Submission Opposing Project Mars Data Centre Development

Application Reference: SSD-82052708

Submitted by: Resident of Wood Street, Lane Cove West NSW 2066

1 21ST DECEMBER - 9AM - PROPOSED
 1 : 2000

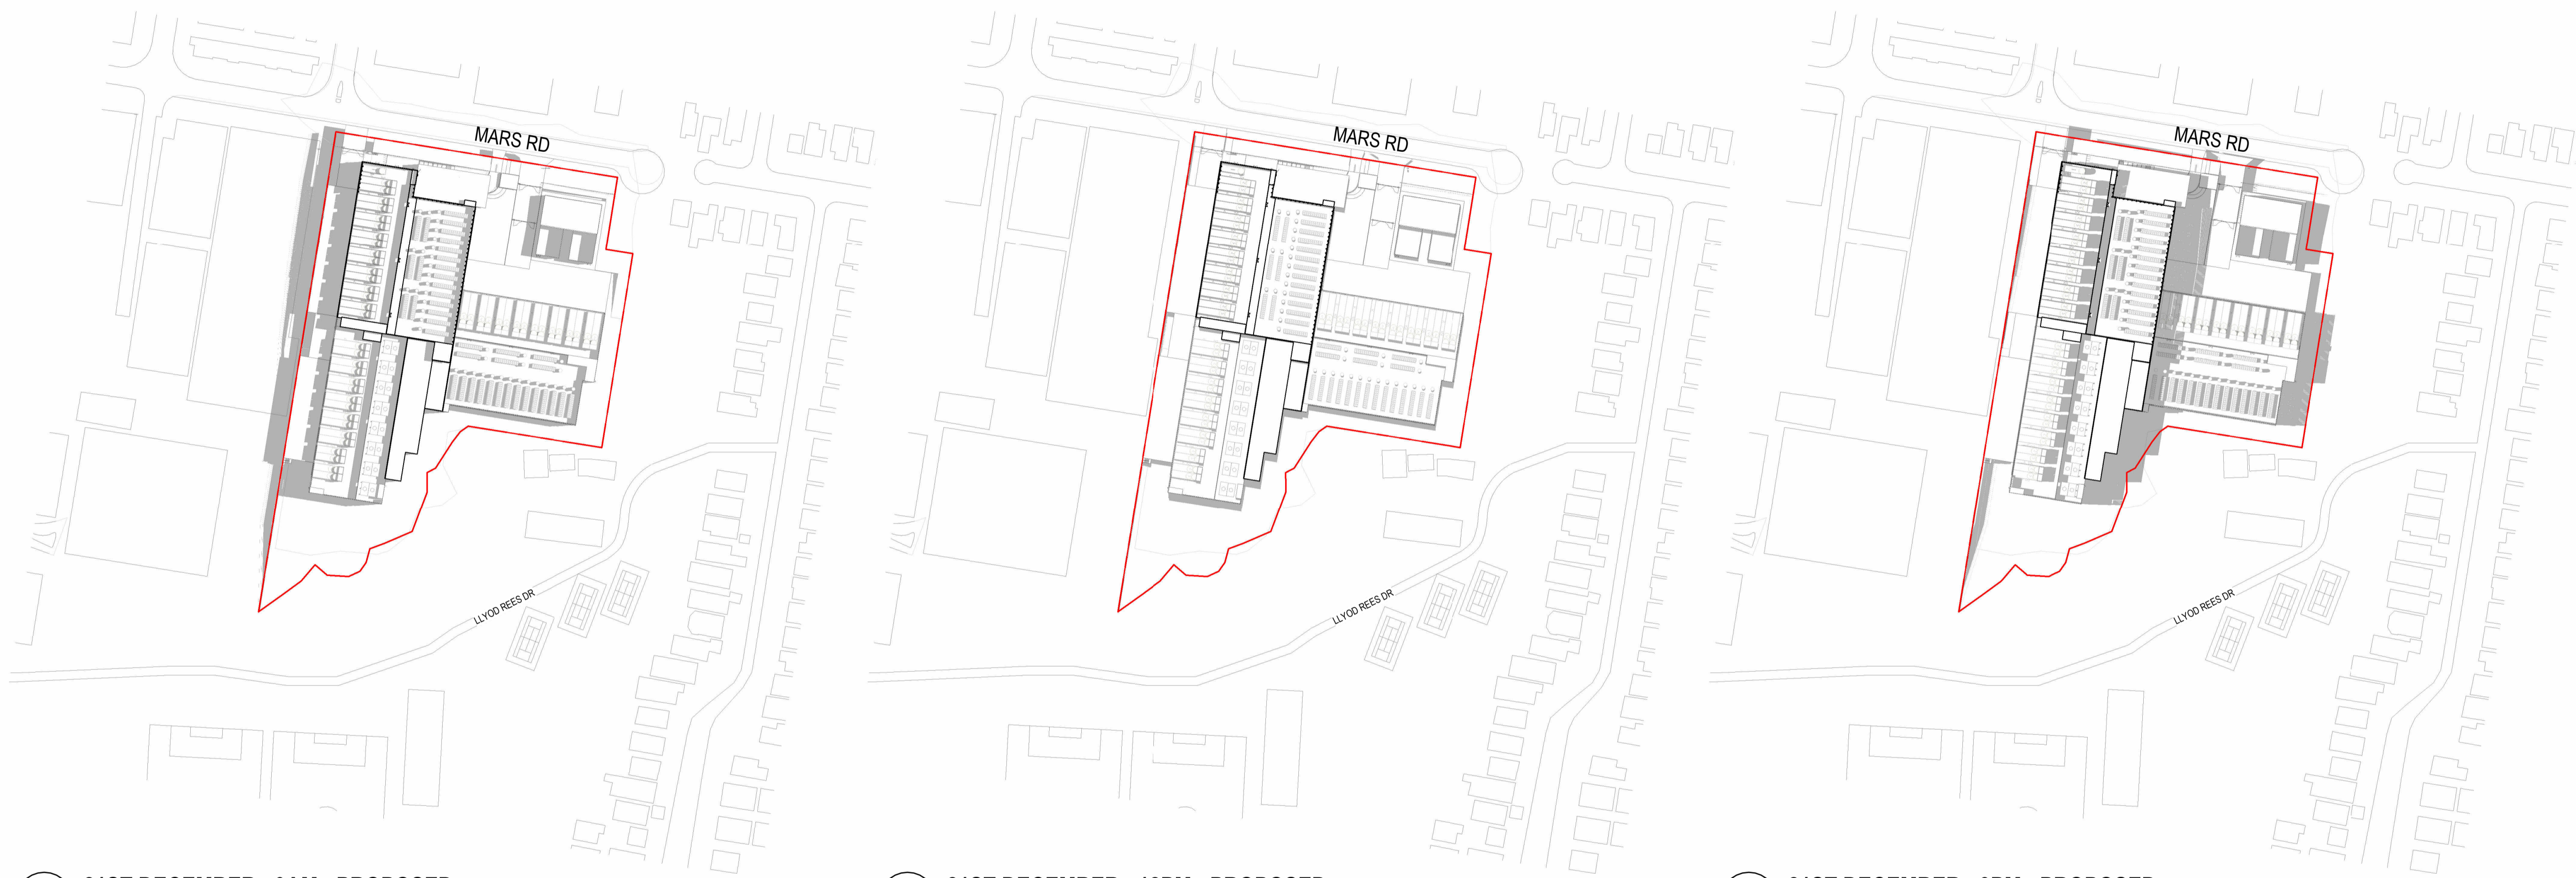
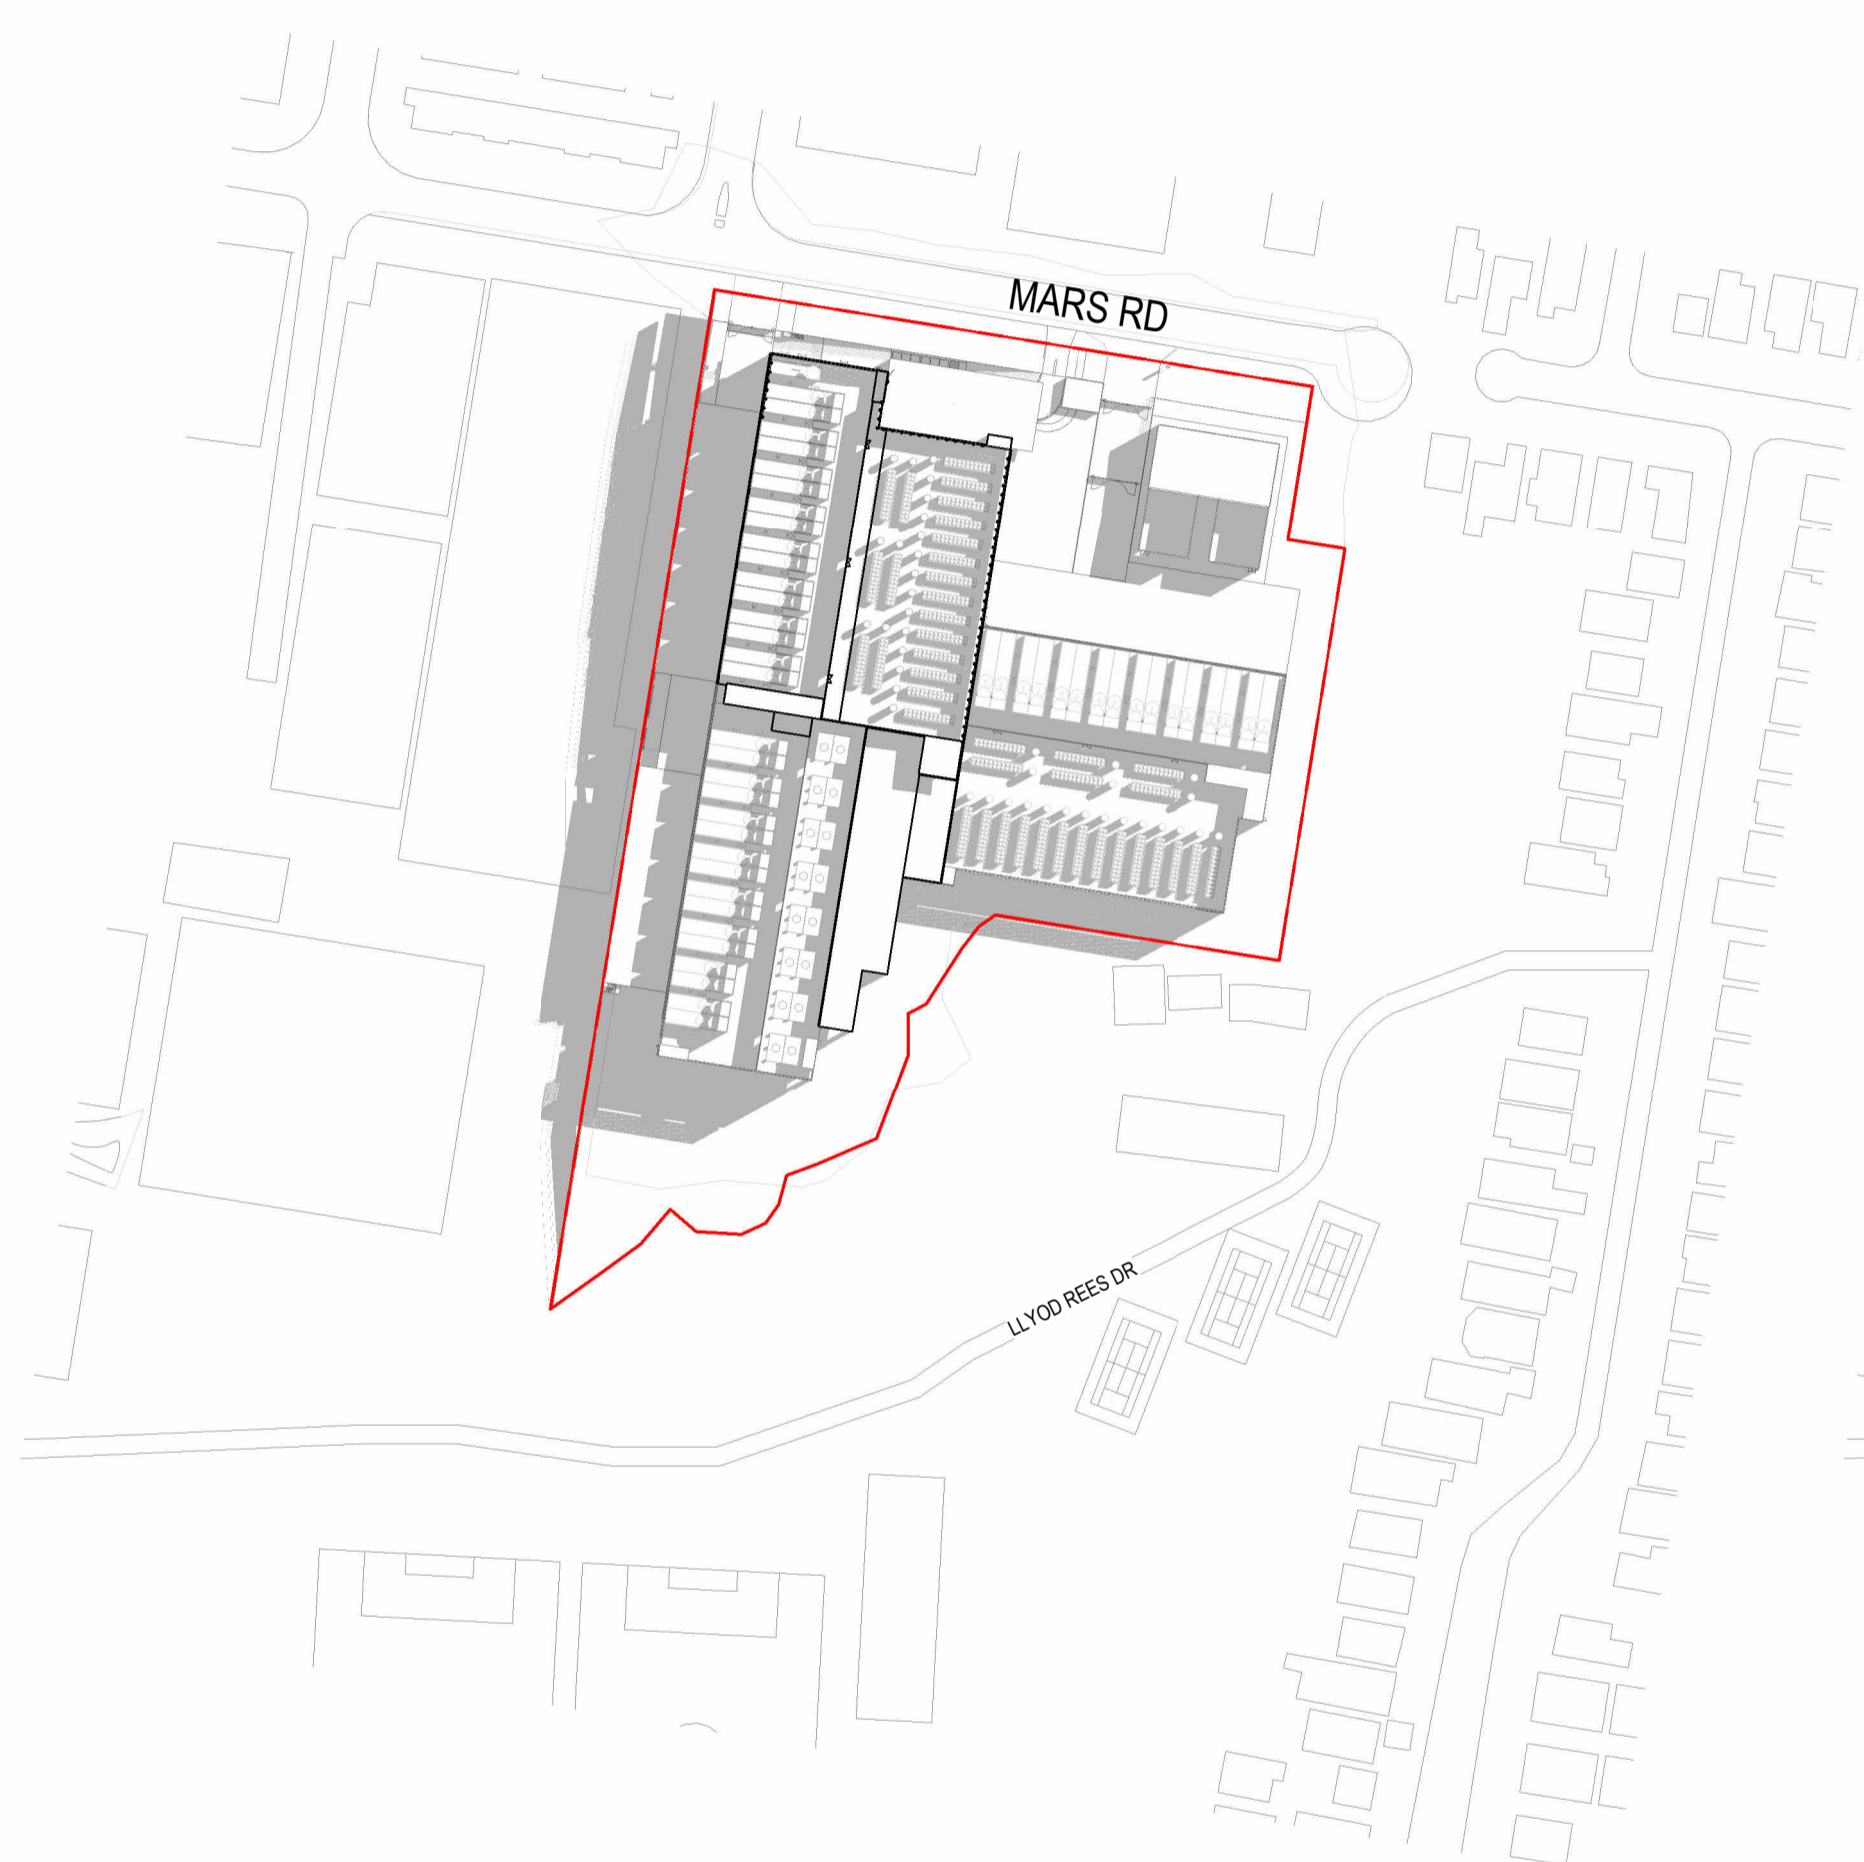
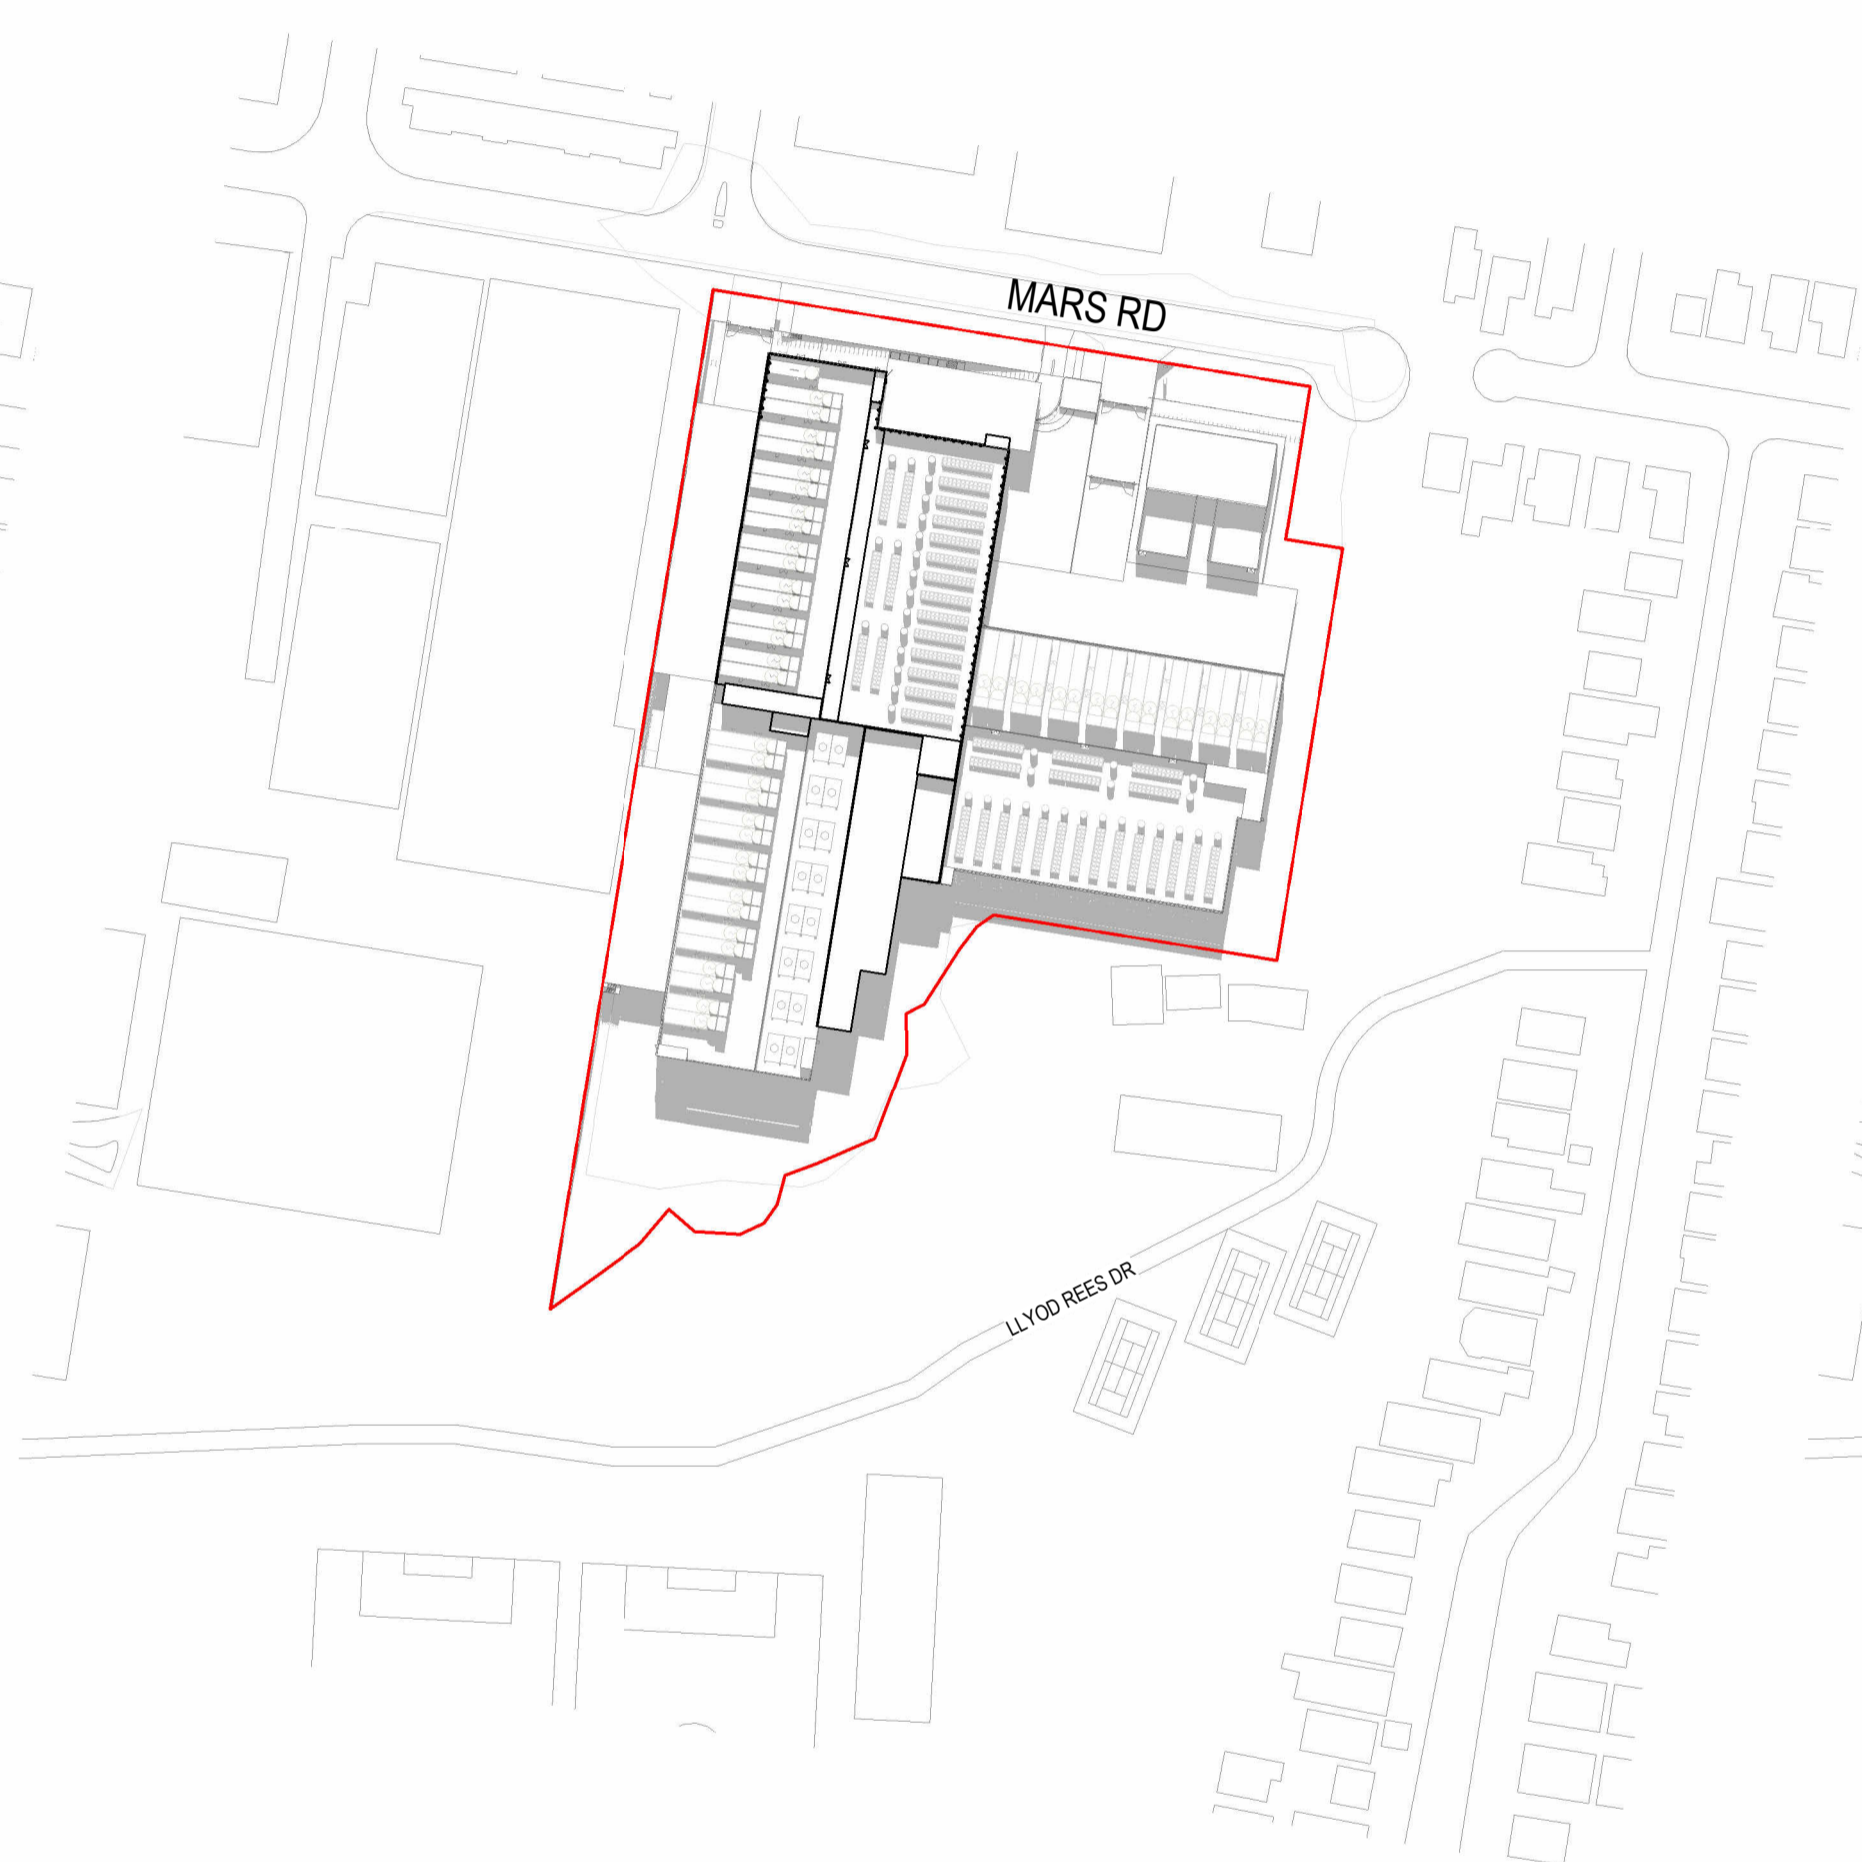
The EIS visual impact assessment uses a limited selection of viewpoints and computer-generated imagery. There are no detailed overshadowing diagrams

demonstrating impacts on Blackman Park across different seasons and times of day. There is no analysis of the loss of residential privacy for homes on Wood Street and surrounding streets, or of the loss of solar access to neighbouring properties and the park.
